**WEST SUSSEX COUNTY COUNCIL
PLANNING SERVICES CONSULTATION**

DATE: 16th November 2017

SUBJECT: LU/278/17/RES - Approval of Reserved Matters following Outline Permission LU/47/11 for Construction of the southern section of the Lyminster Bypass, including northern and southern roundabouts, surface water drainage and landscaping. Departure from the Development Plan & affects a Public Right of Way.

LOCATION: North Littlehampton Strategic Development Site, Land West of Toddington Park, Toddington Lane, Littlehampton, BN17 7PP.

Landscape Proposals SLB2

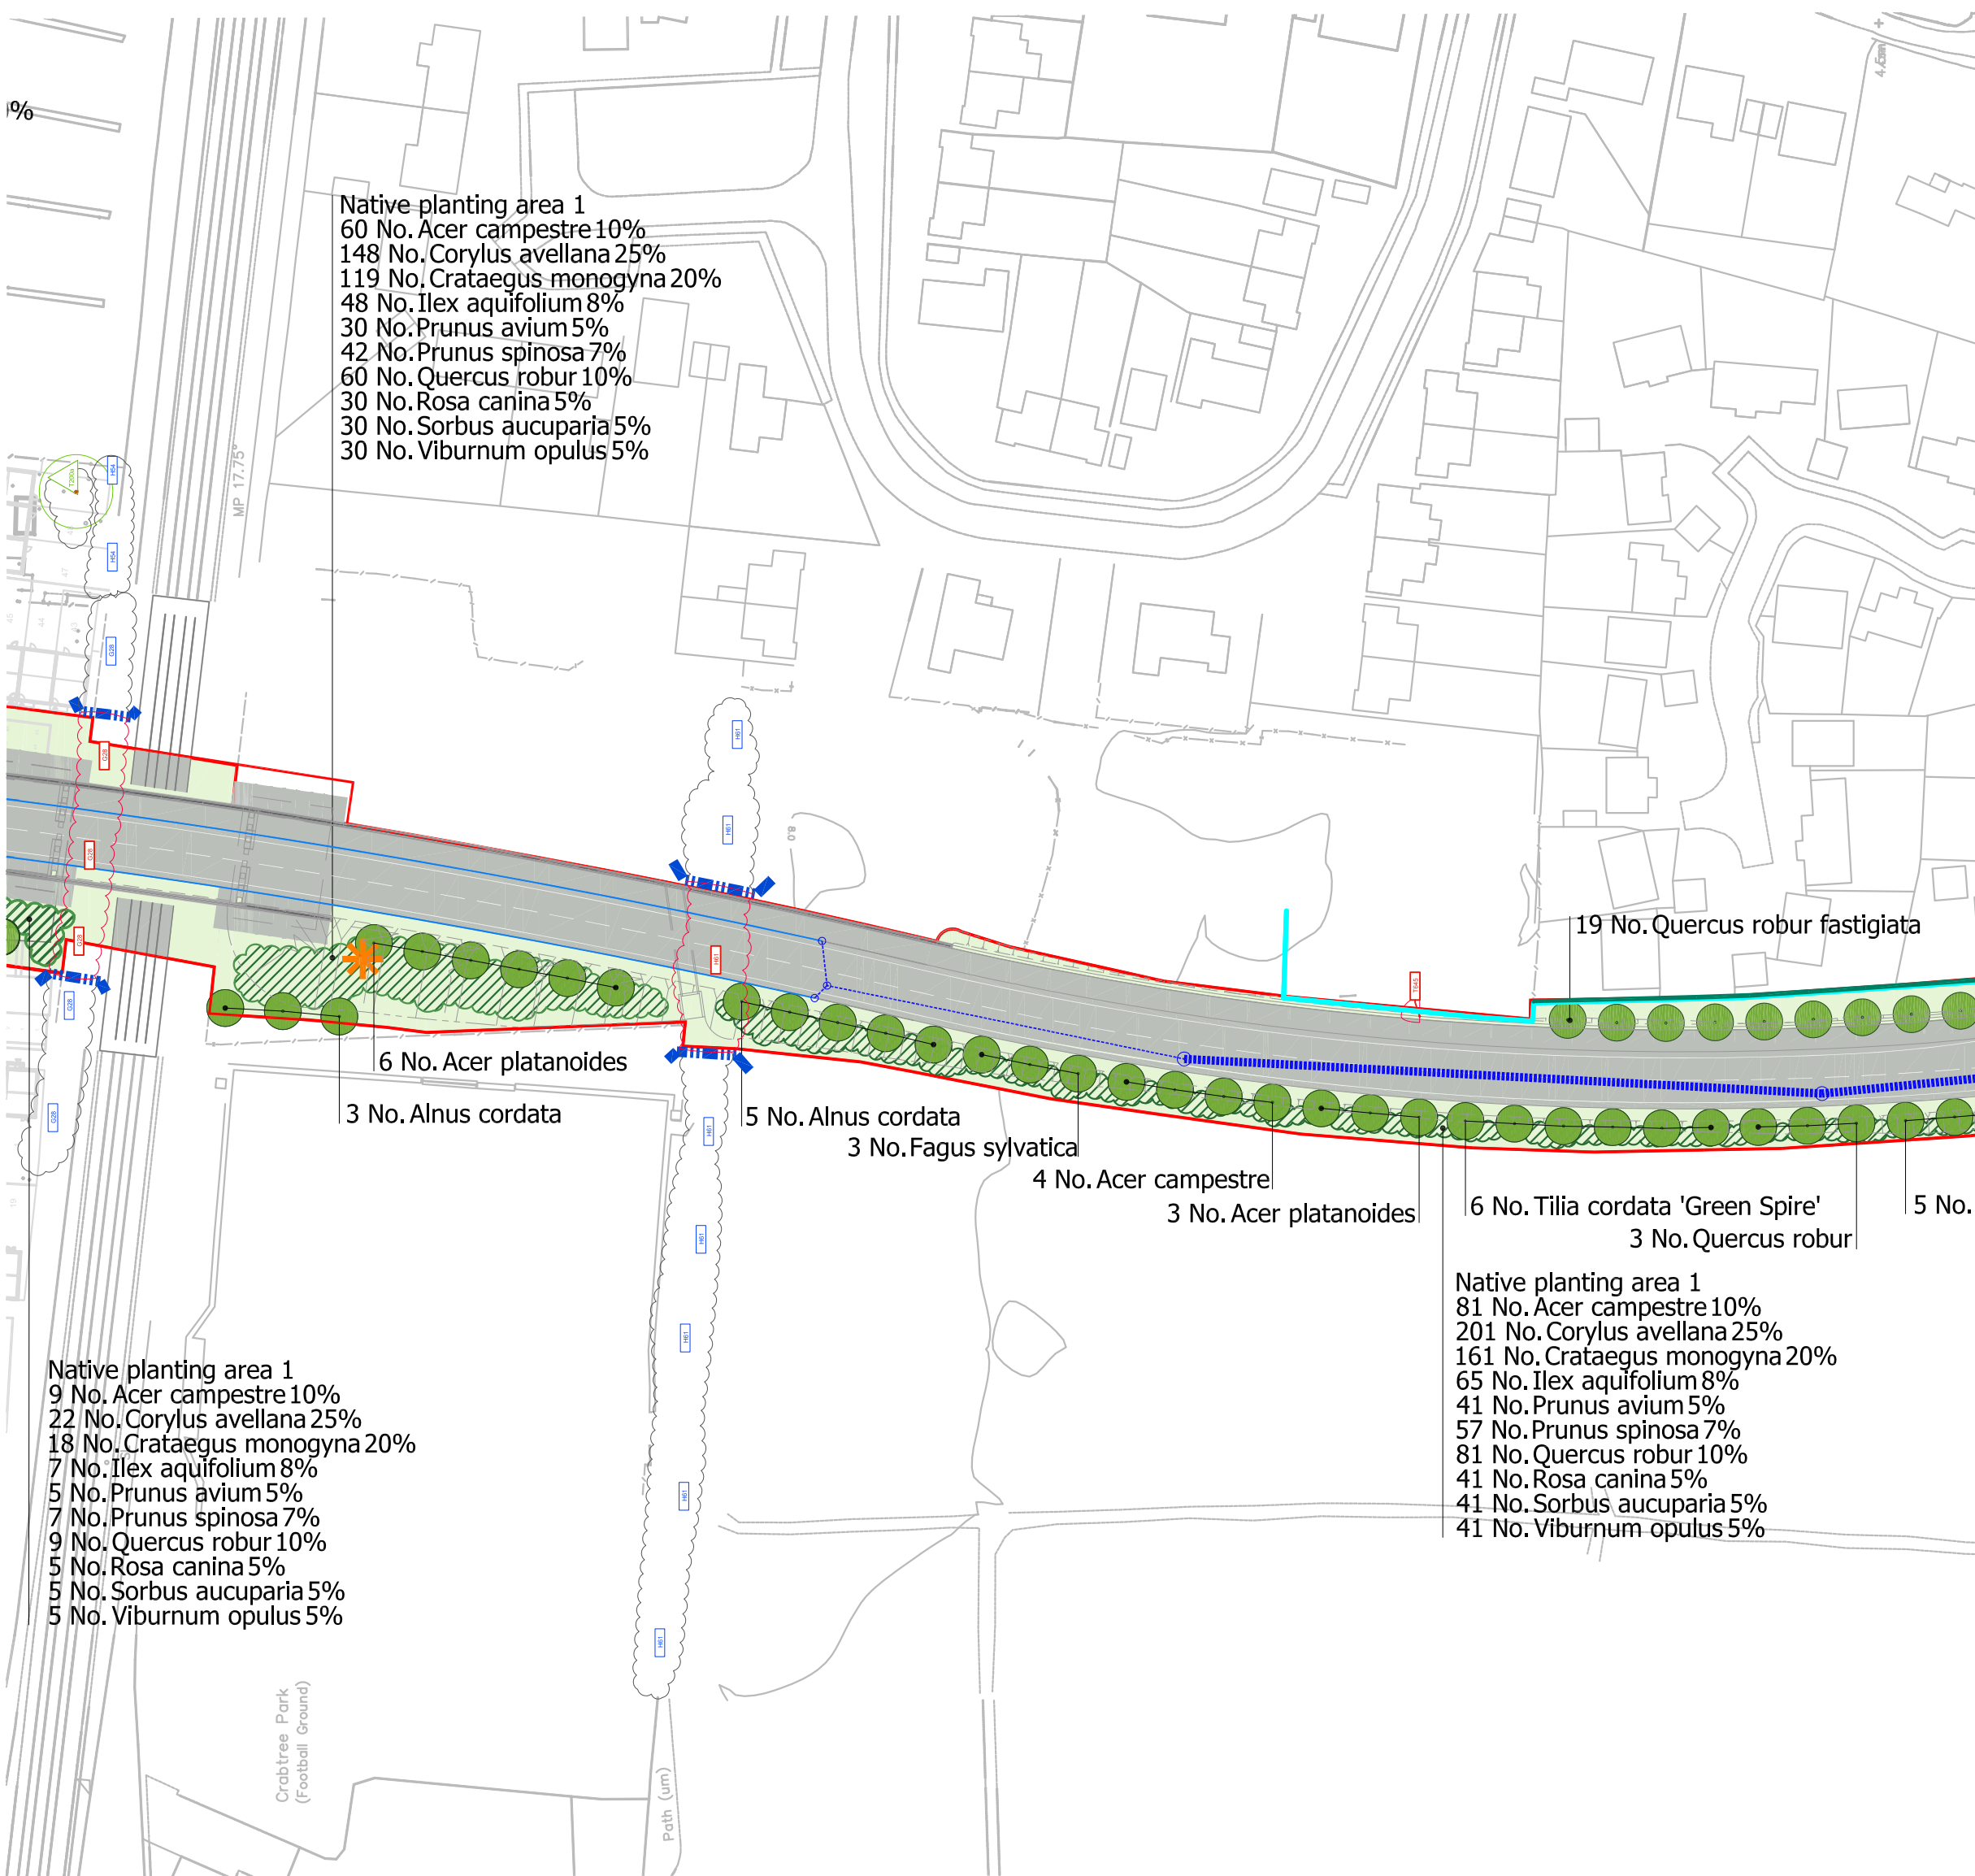
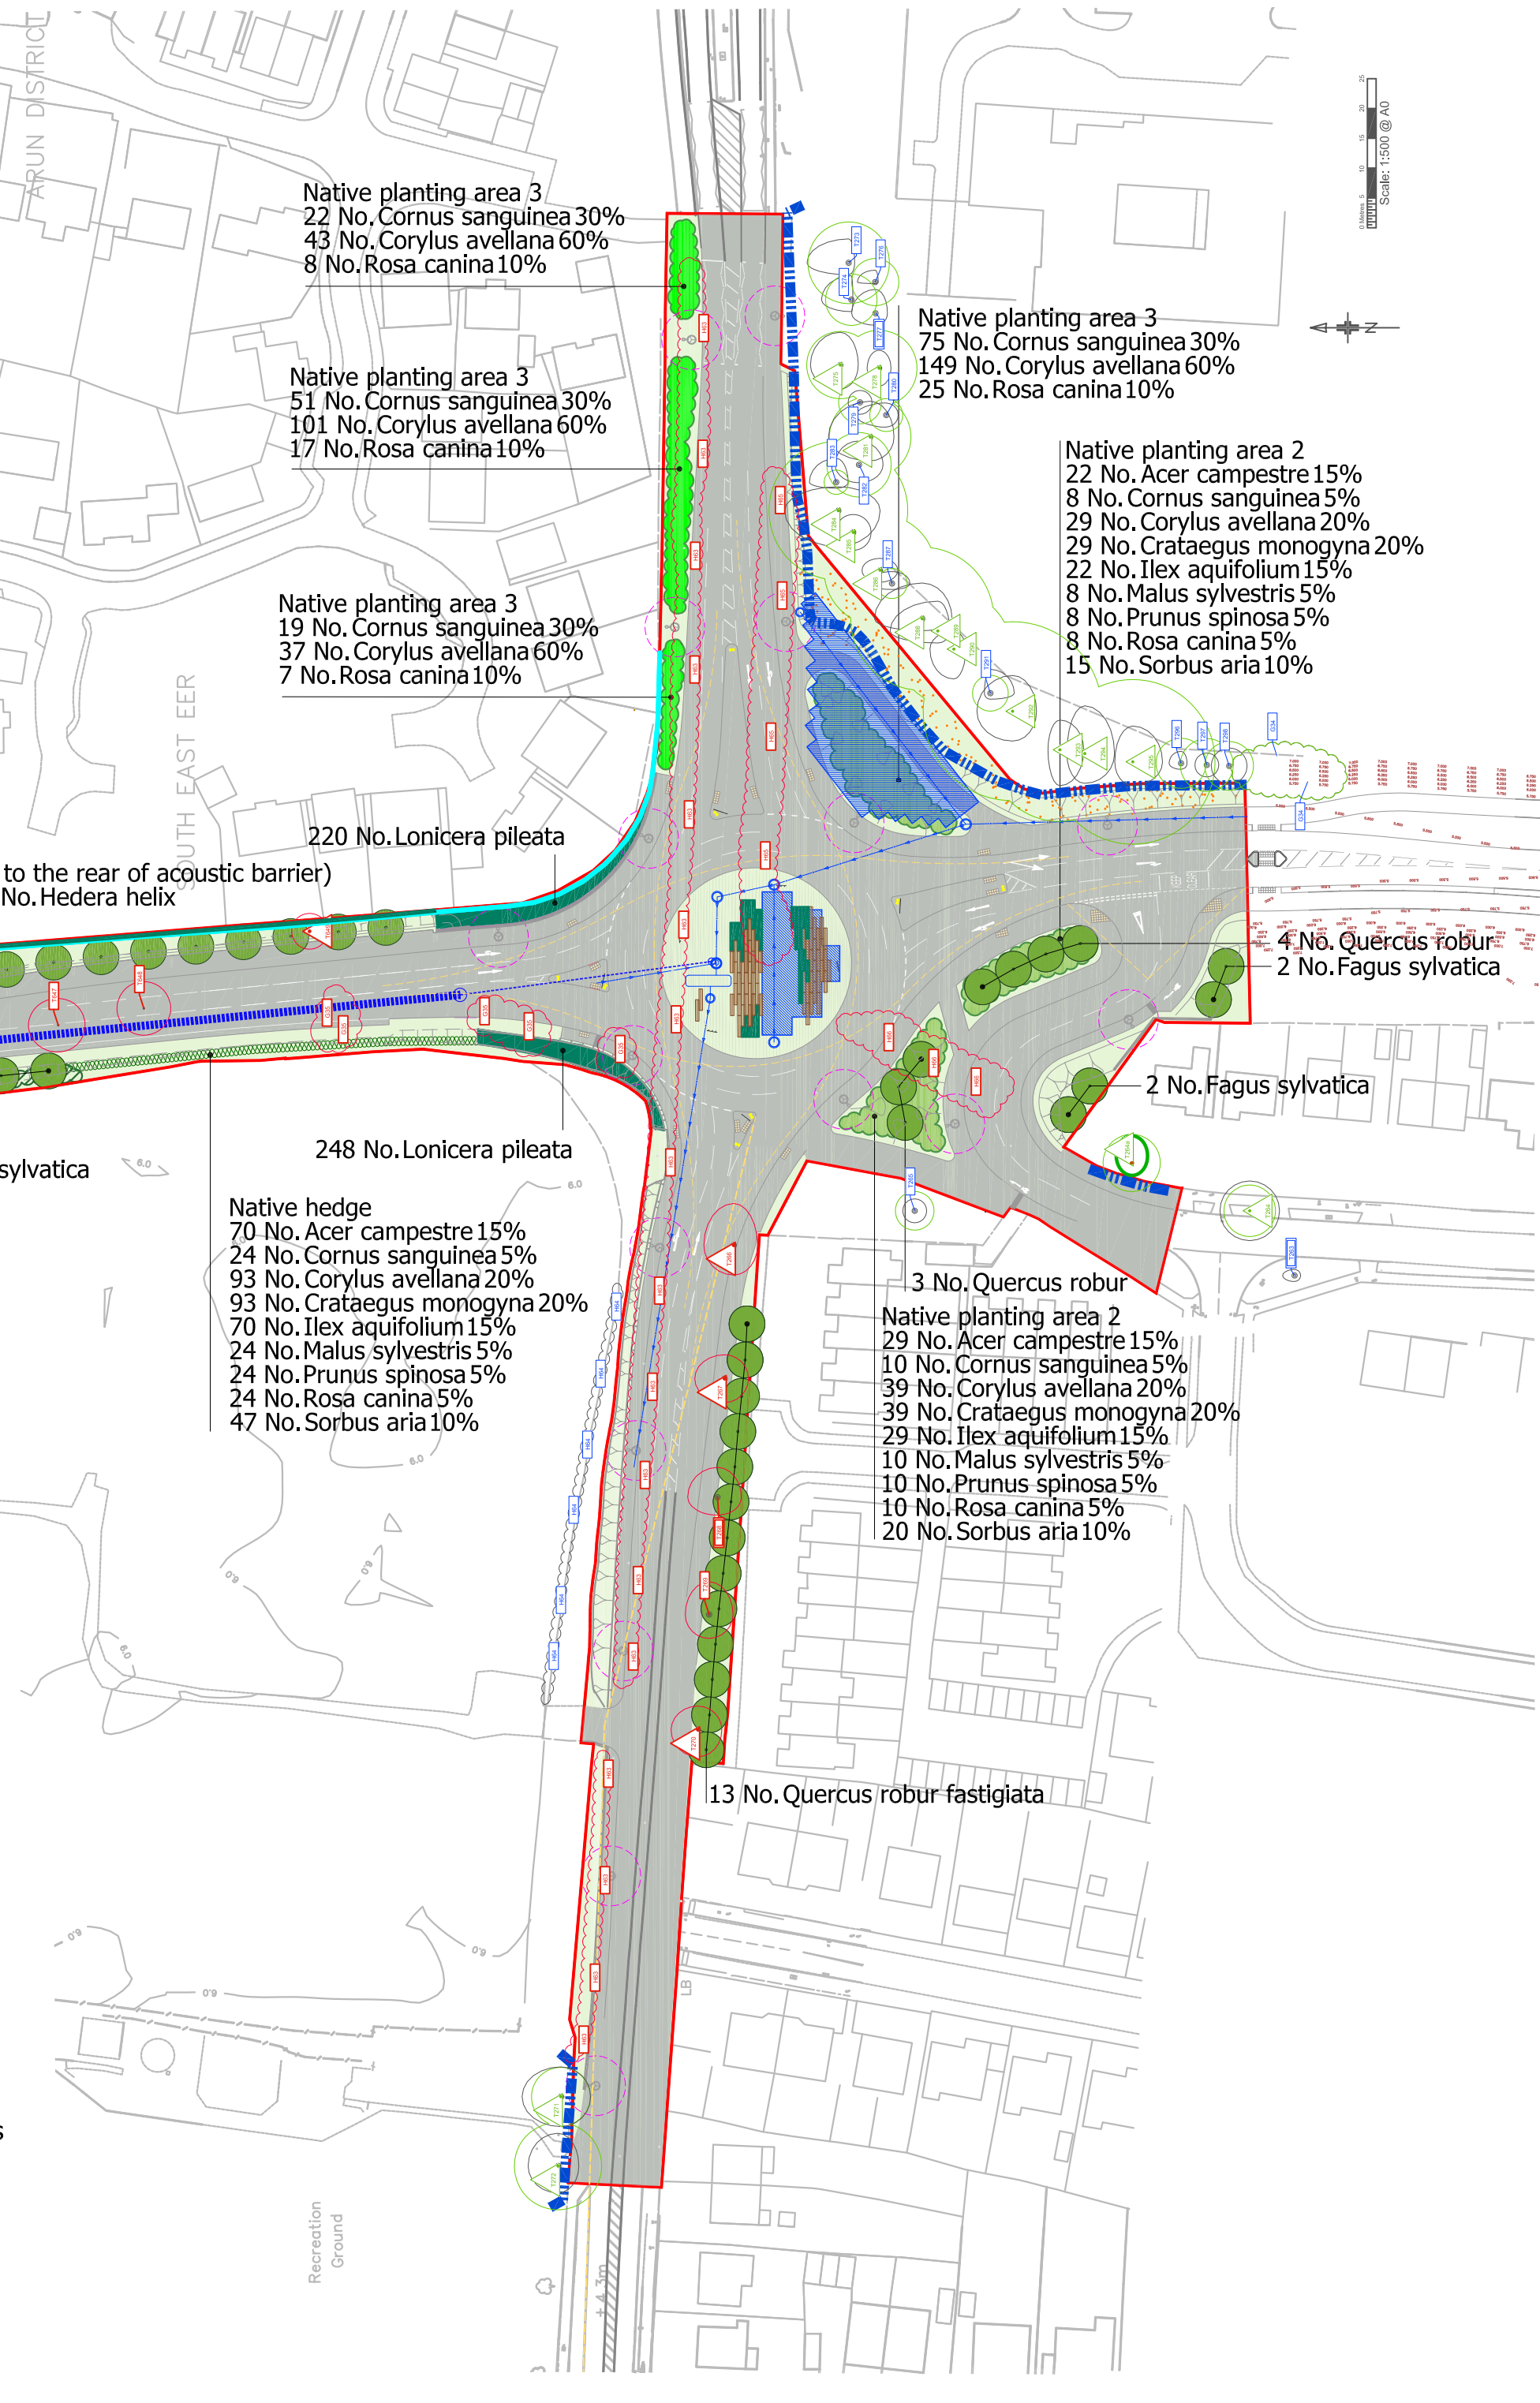
- 1. WYG – Landscaping proposals SLB2 Plant Schedule 2 of 2 – A088461 SLB1-SLB4.dwg - August 2017.**
- Visibility reqs. at points where visibility plays are required (ped and vehicular).

LYMINSTER BYPASS - SOUTH
NORTH LITTLEHAMPTON
PROPOSED ROAD ALIGNMENT AND
CONTOURS

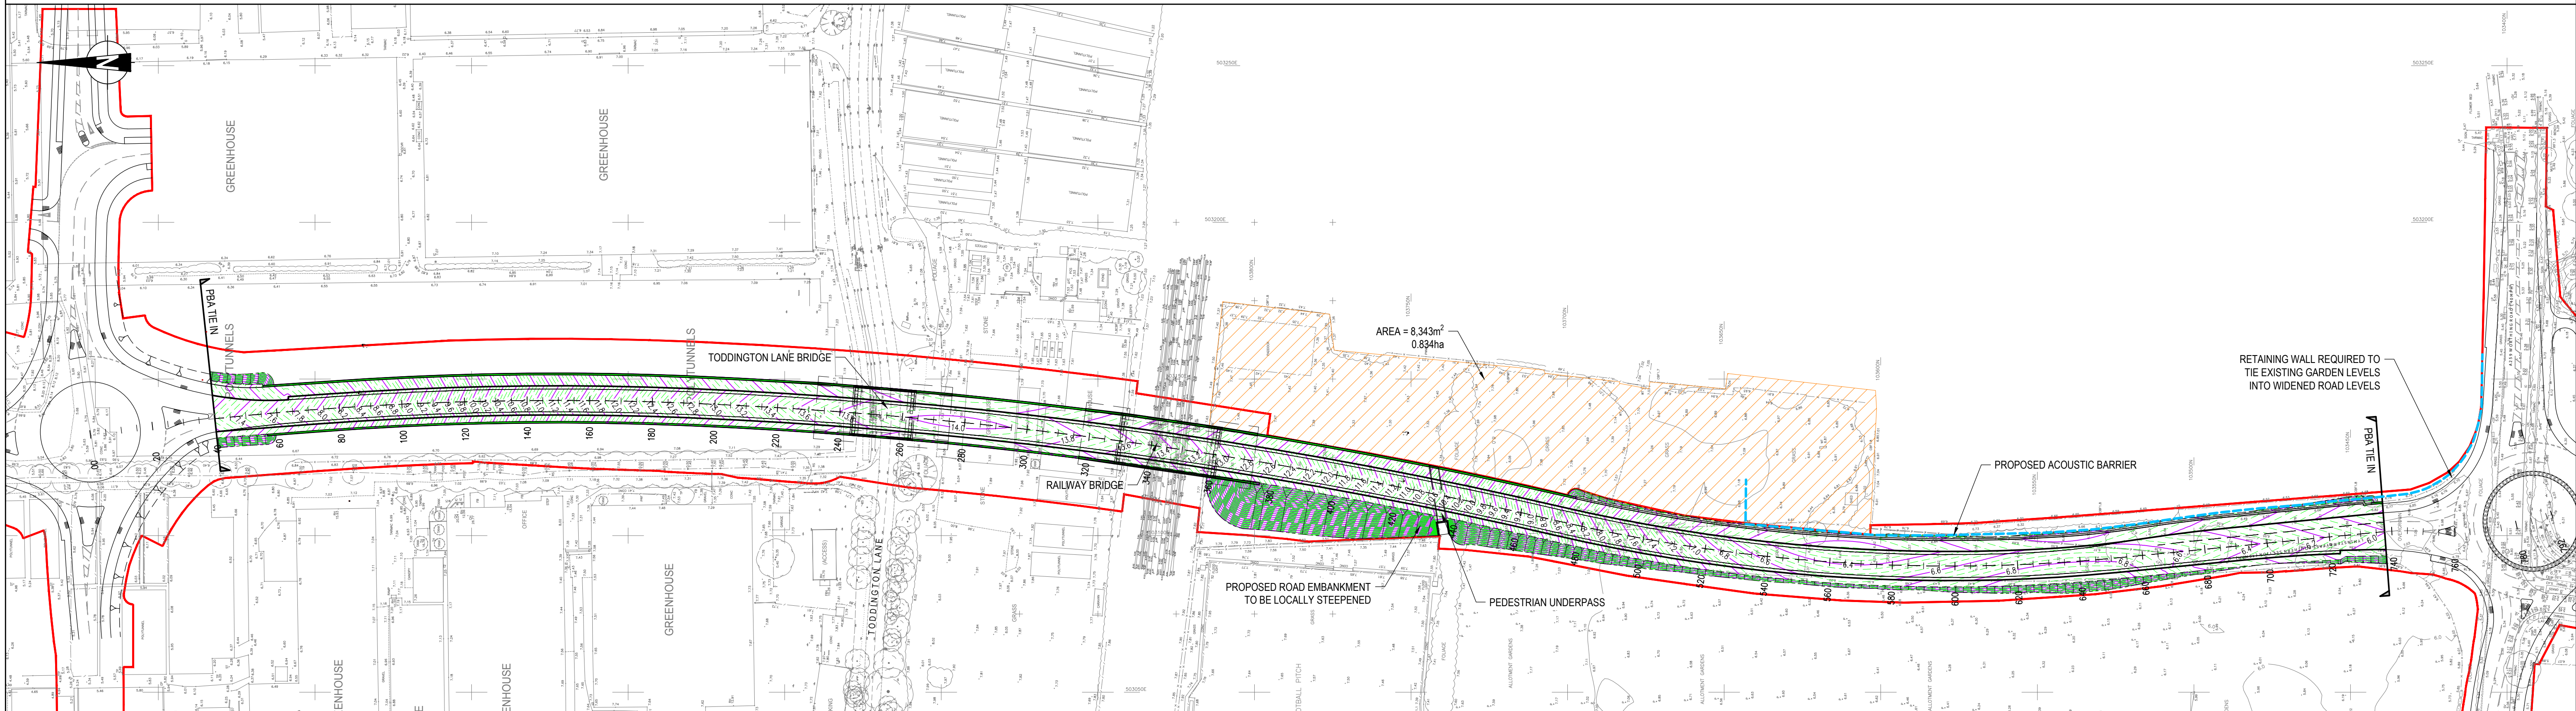
Alignment seems to suggest that it achieves a desirable minimum SSD forward visibility envelope for an 85kph design speed, based on the drawings provided to date. This will be verified when the Design Check is provided and reviewed.
